Response to Issues – Department of Planning and Environment

80-88 Regent Street, Redfern – SSD 7080

Issues raised by DP&E in October 2016

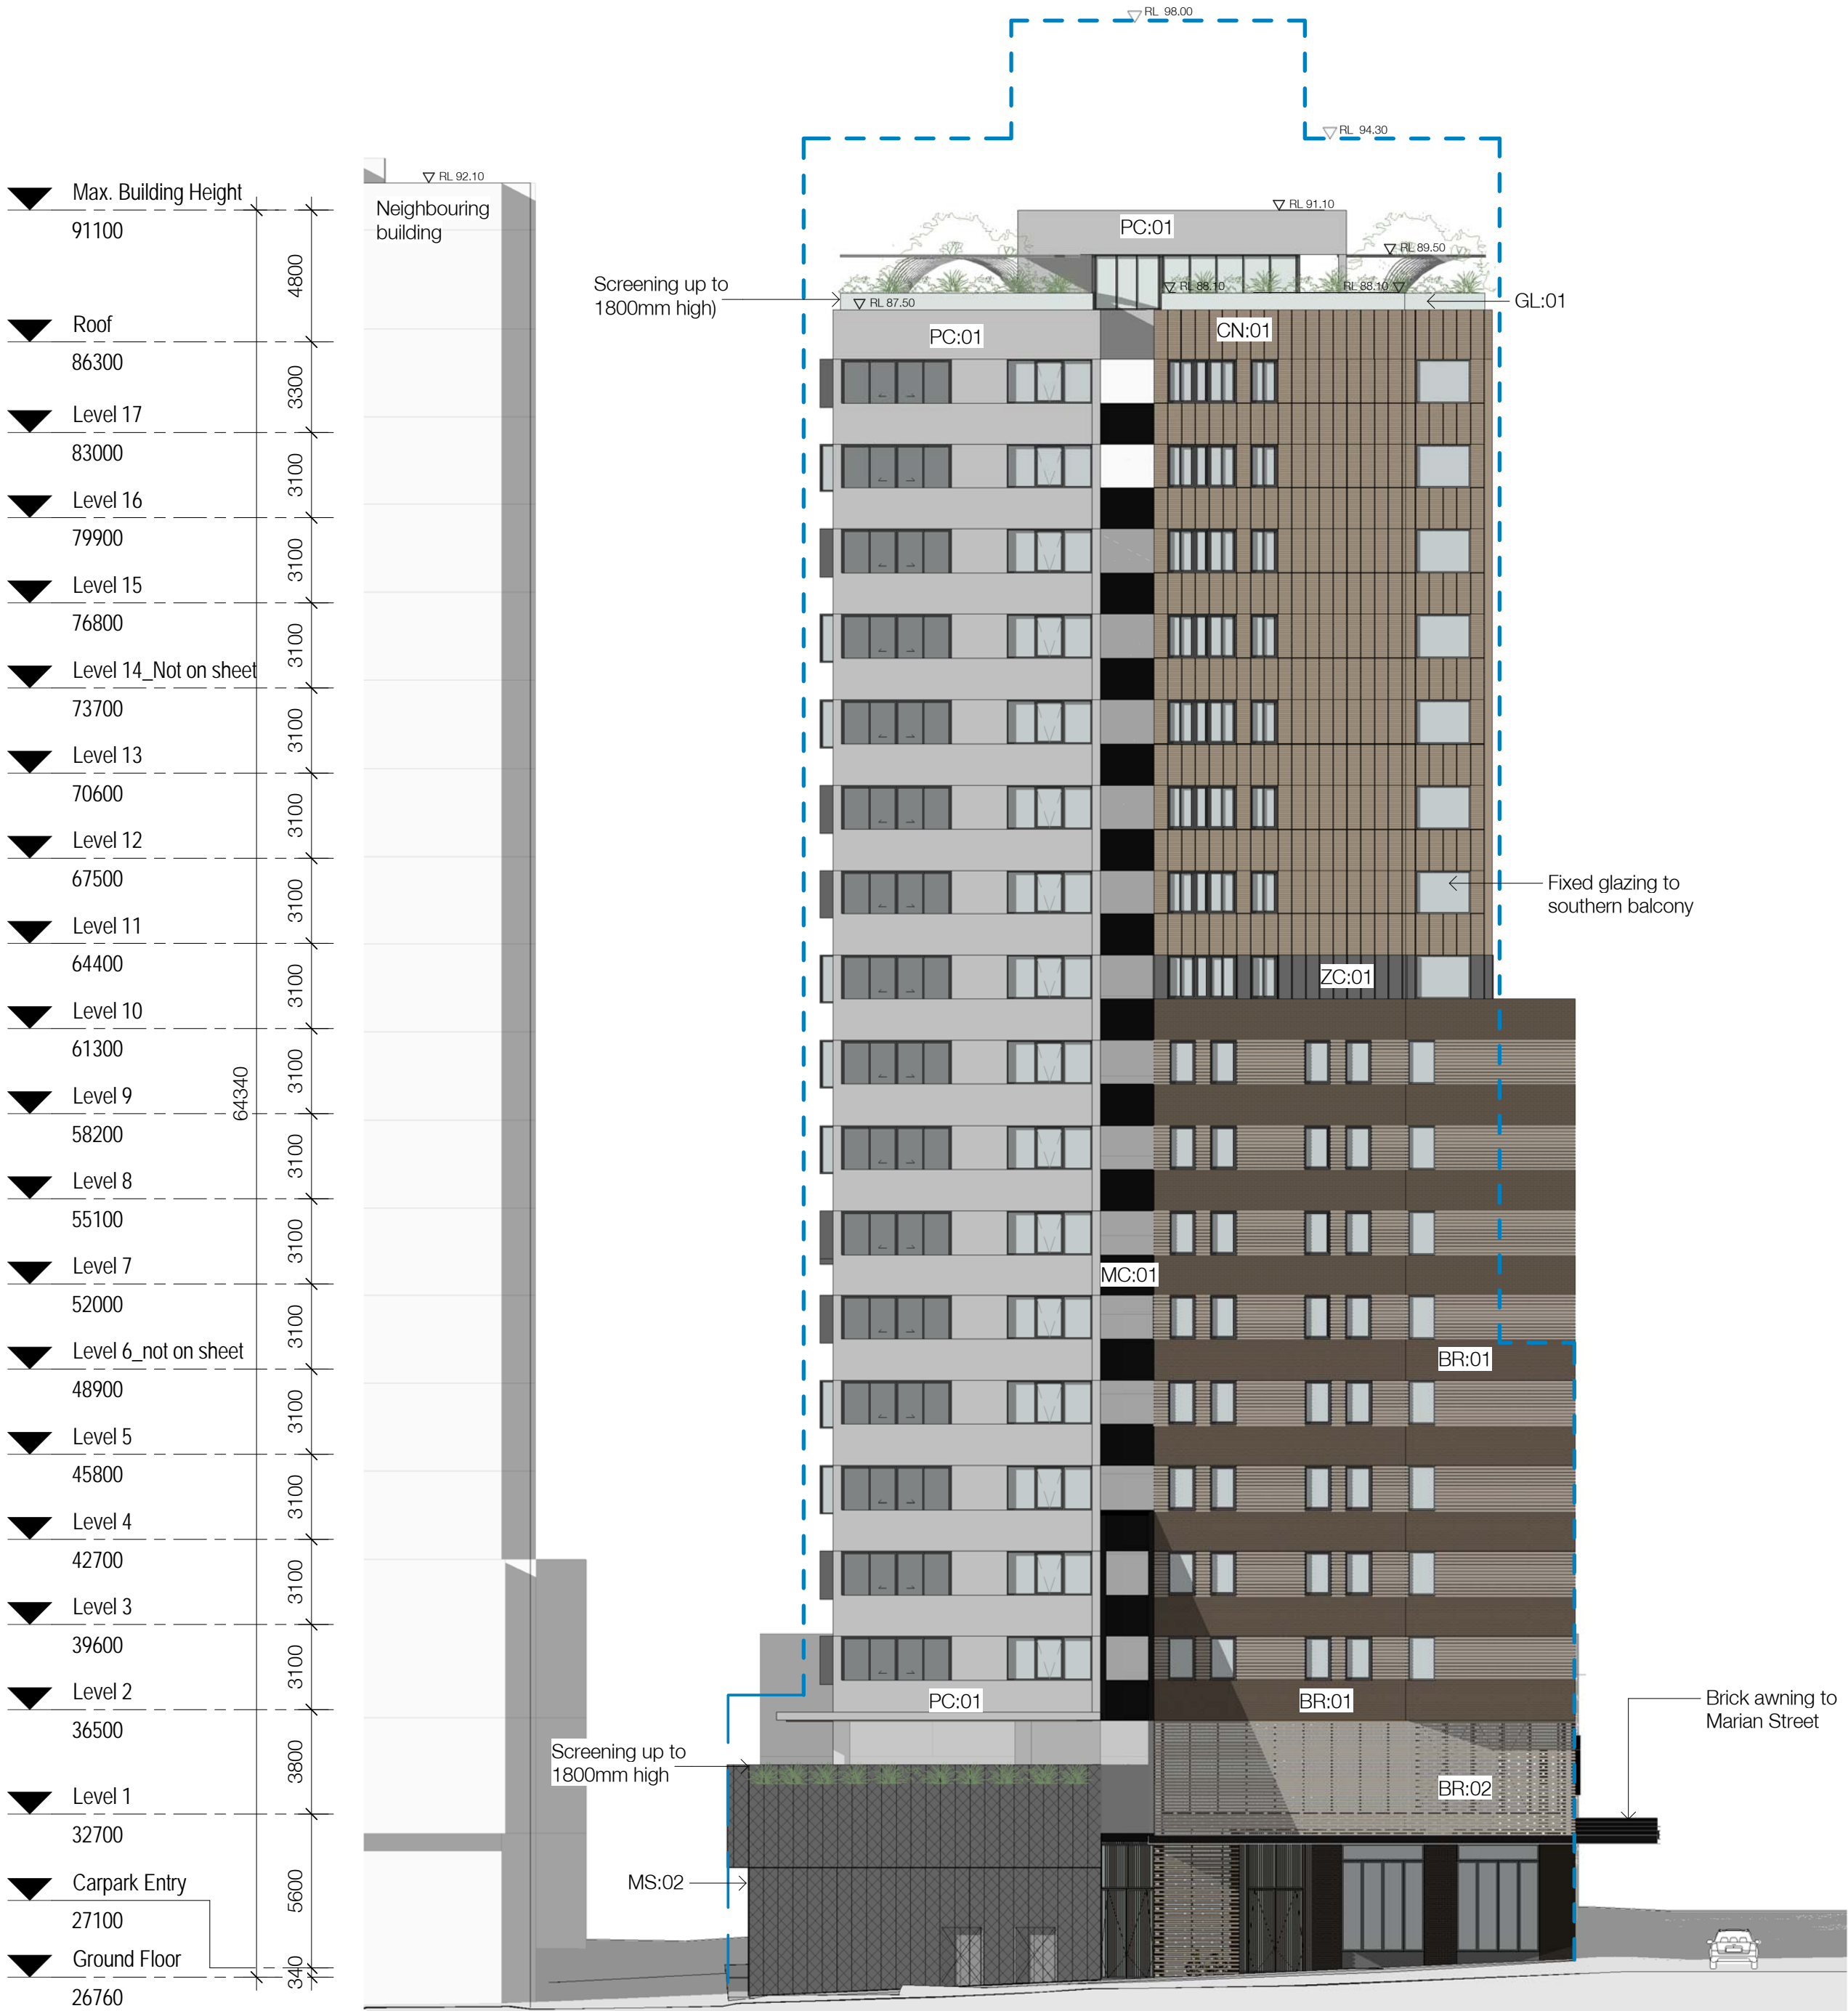
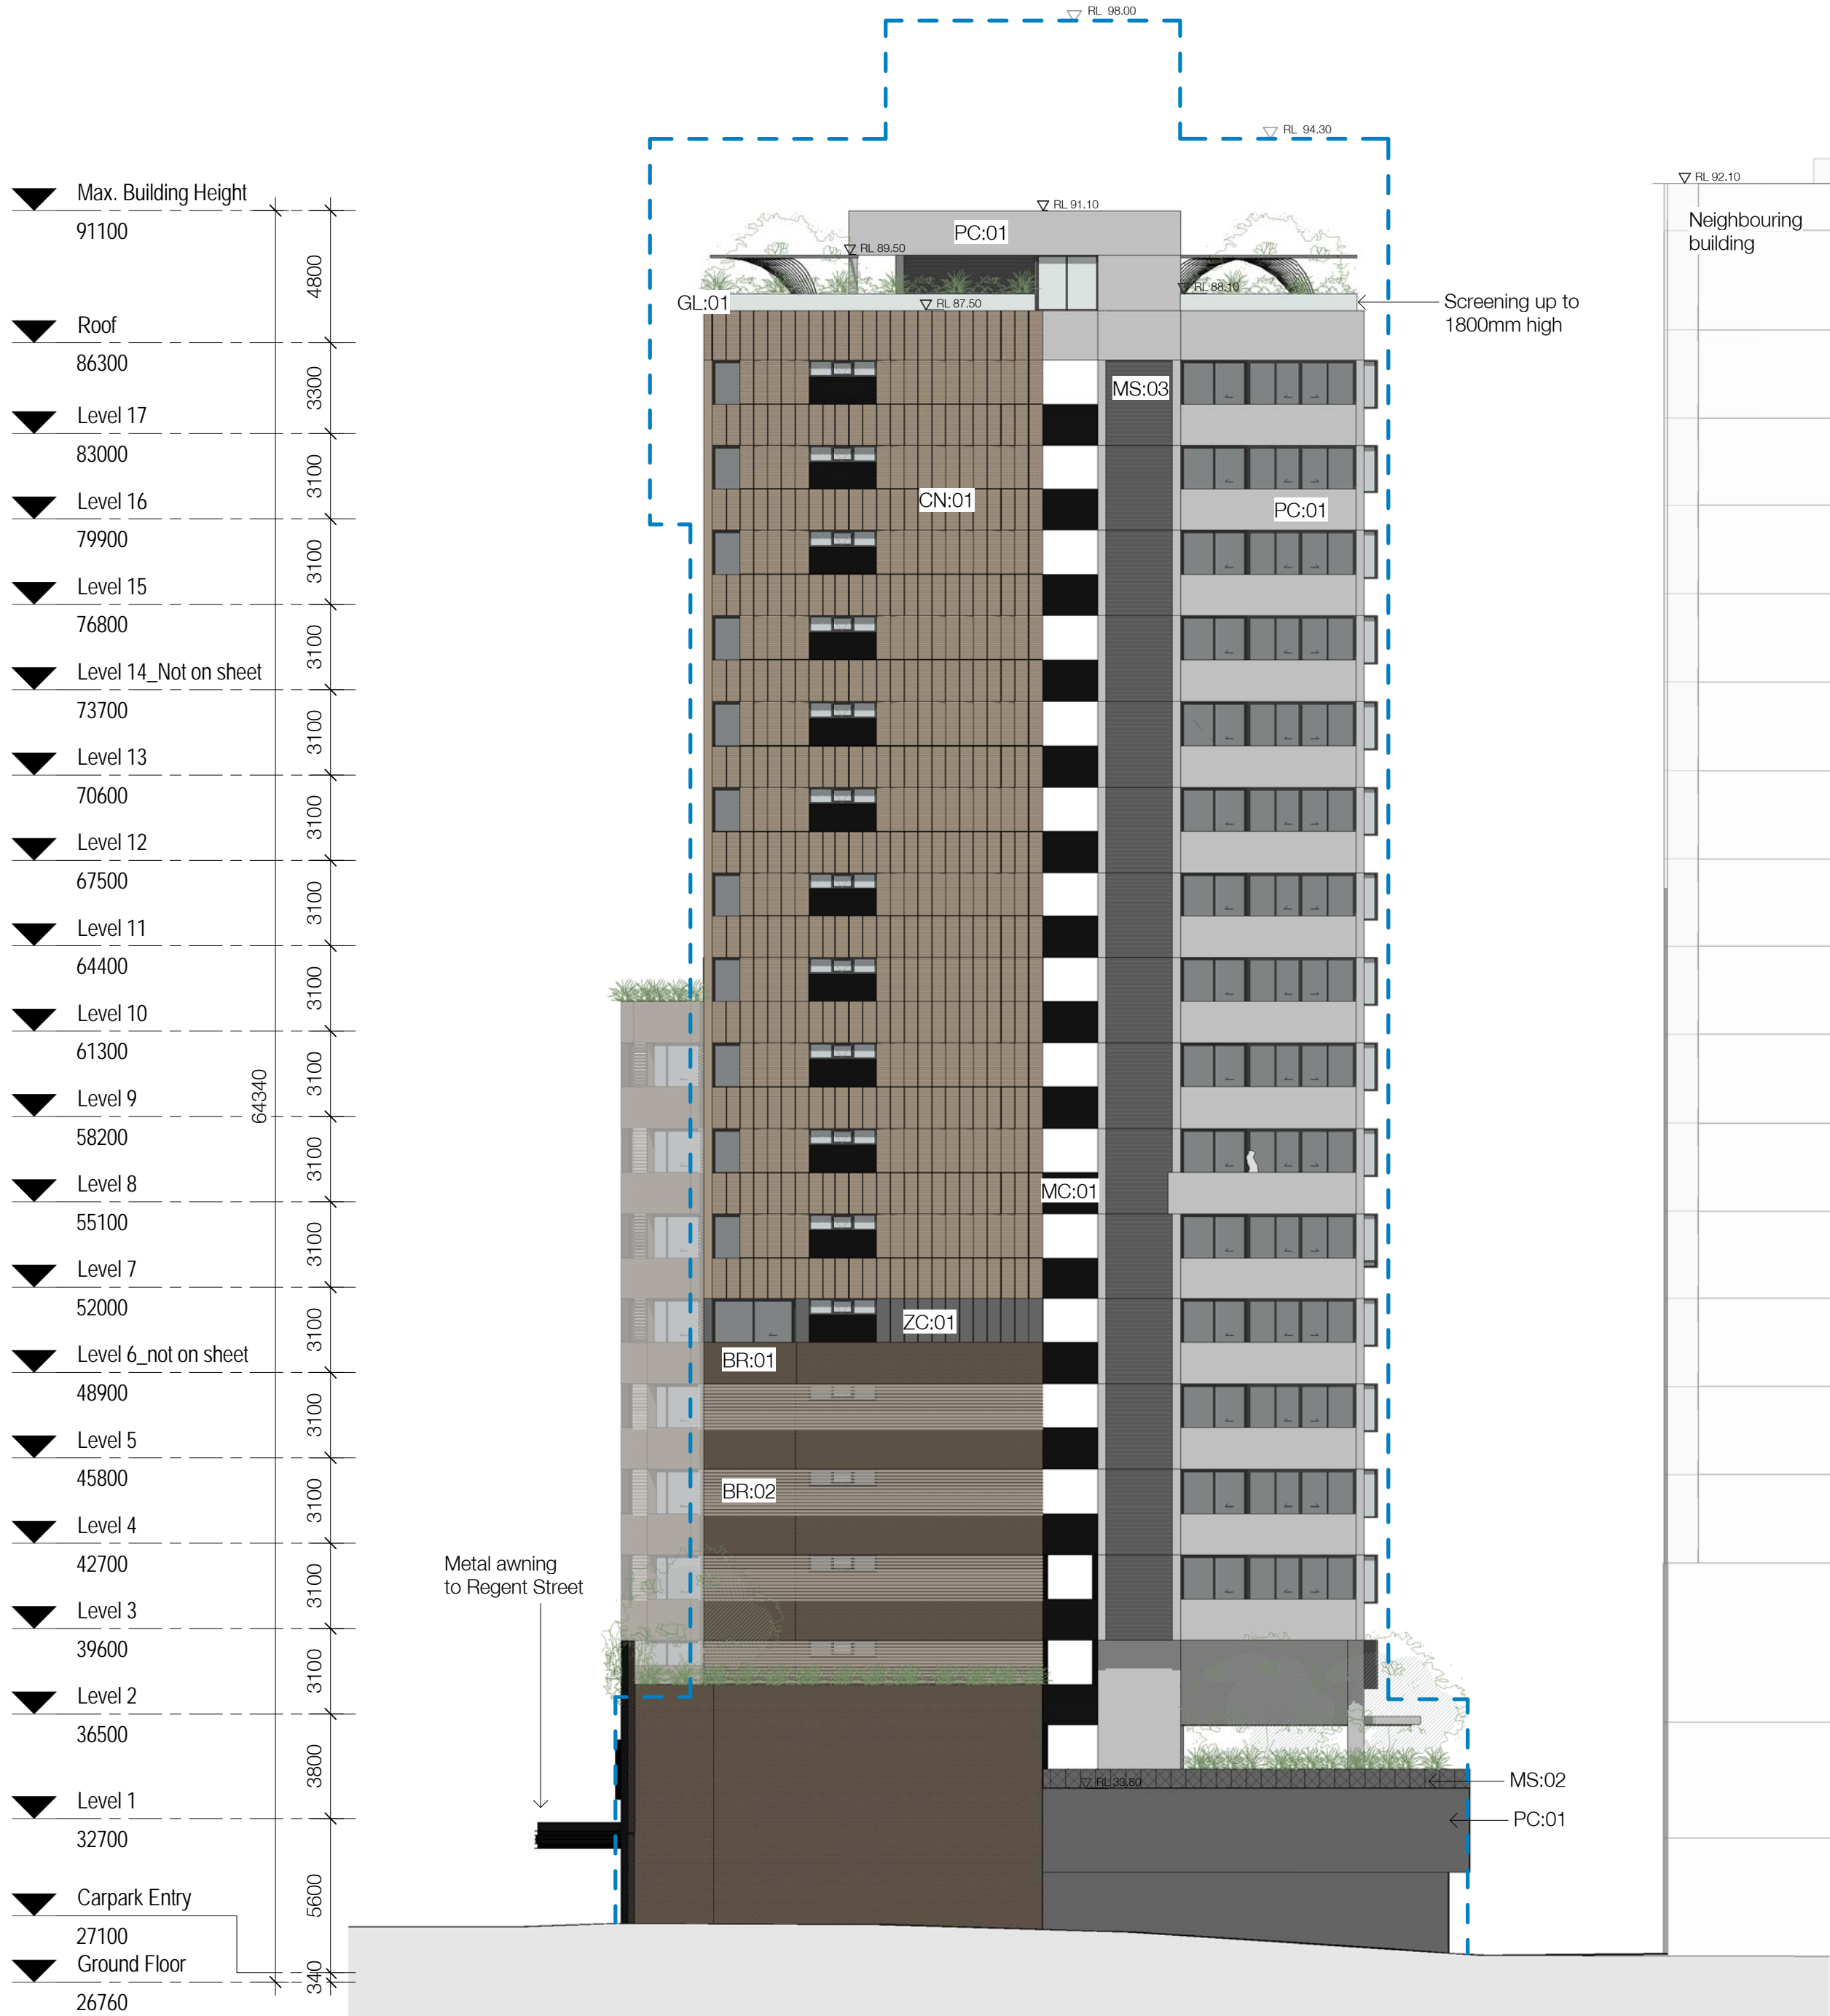
Height and GFA	<i>7. Detailed plans should be provided to illustrate the proposed height of the building relative to the height of existing and proposed buildings in the area.</i>	Relative heights of adjoining buildings have been included on amended architectural drawings.	Refer to section 4.1 and Attachment 1.
	<i>8. Further consideration of the number of storeys is required to justify compliance with the height controls for the site; and</i>	Building height has been reduced.	Refer to Section 4.1 and Attachment 1.
	<i>9. Clarify the Gross Floor Area (GFA) provided to justify that the proposal can comply with the planning controls for the site.</i>	Proposal has an FSR of 7:1 and complies with the maximum FSR of 7:1.	Refer to section 4.3 and Attachment 1
Setbacks, Building Separation and Design Response	<i>10. Additional justification is required to demonstrate how the proposed built form and setbacks have considered, addressed and minimised impacts on adjacent residential amenity, including privacy, views, outlook, ventilation and solar access, and specifically, how the proposed built form and setbacks do not increase amenity impacts beyond those envisaged by the planning controls for the site.</i>	Setbacks have been amended. Setbacks minimise amenity impacts.	Refer to Section 4.2 and Attachment 1.

04. Revised DA non-compliant tower and podium setbacks

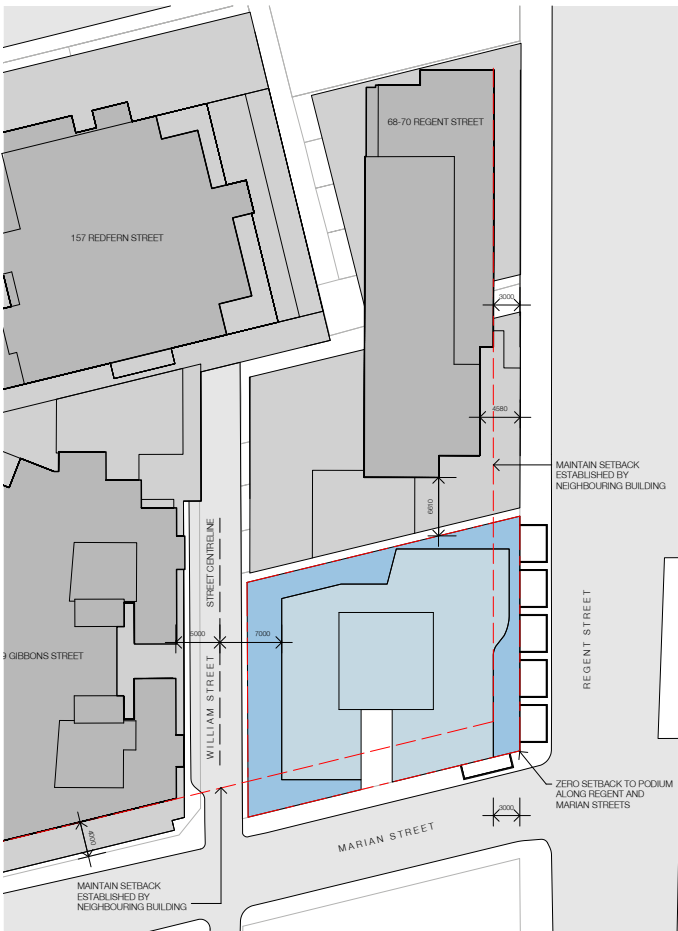
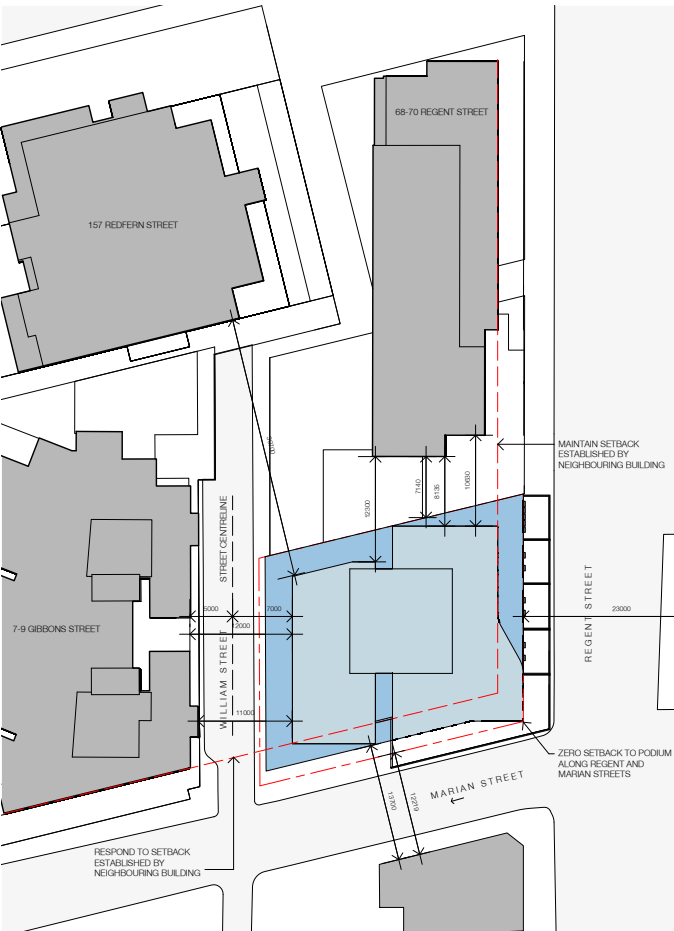
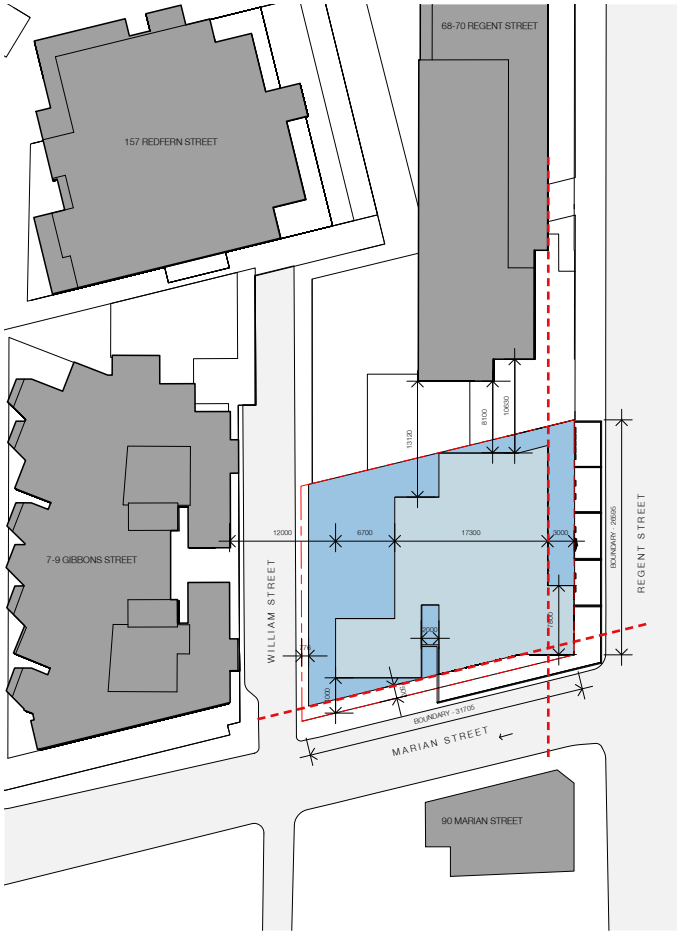
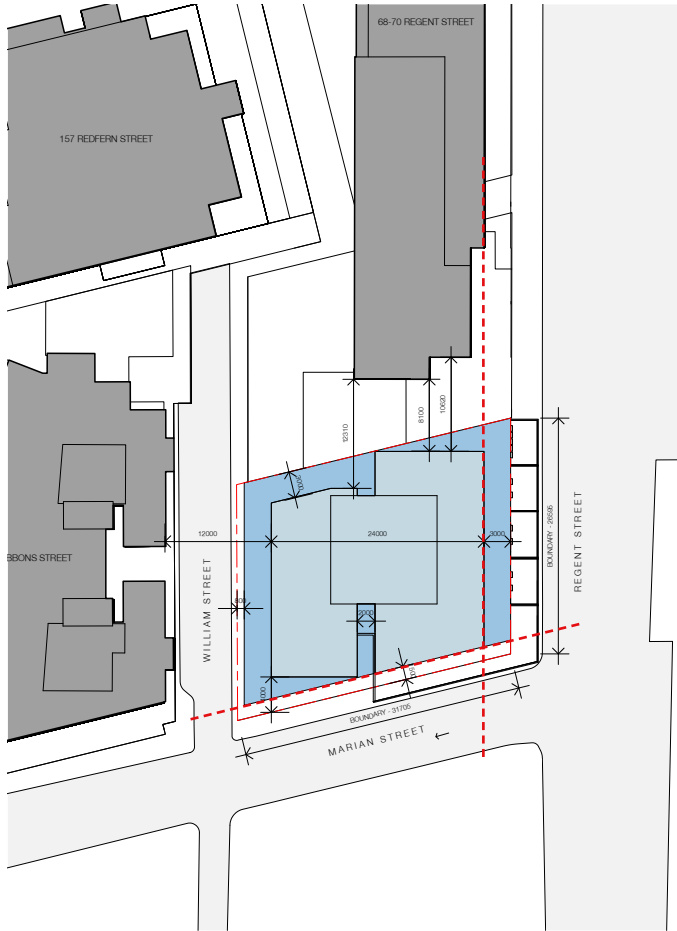
Matter	Particulars of Issues	Response	Location in Report
Building separation	<i>Demonstrate there are no undue impacts on amenity as a result of decreased setbacks (privacy, overshadowing, views and wind) compared to a compliant scheme.</i>	The proposal will not have undue amenity impacts in terms of overshadowing, privacy, or view loss as a result of variations to building setbacks.	Refer to section 4.4.2, 4.4.3, 4.7.1, 4.7.2, 4.7.3, 4.7.4 and 4.7.5
Street setbacks	<i>William Street - issue of doors opening to William Street (particularly close to the corner at Marion Street).</i>	Doors required to service substation. Measures can be put in place to reduce potential safety issues arising from doors.	Address through conditions.
	<i>Marion Street - increased setback to Marion Street.</i>	The tower setbacks on Marion Street have been increased to predominant setback of 3.15m.	Refer to section 2.2, 4.2.2 and Attachment 1.

Matter	Particulars of Issues	Response	Location in Report
Design options	<i>1. Further consideration is required of alternate viable design options for the site, with particular regard to the setbacks from the northern and western boundaries, to demonstrate that the preferred building envelope and built form is the best design solution for the site.</i>	The envelope of the proposal has been amended, with a reduction in height and minor increase in setbacks.	Refer to section 4.1 and 4.2.
Design Excellence	<i>Further information is required with regard to design excellence, including: 2. The amenity and quality of the public domain (see points 5 and 6); 3. Consistency with best practice sustainable design principles; and 4. Further consideration of the scale, form and height of the podium to ensure that the proposal respects the local character, topography and fabric of Regent Street.</i>	The public domain has been enhanced with a revised ground plane that enhances activation.	Refer to amended architectural plans at Attachment 1.
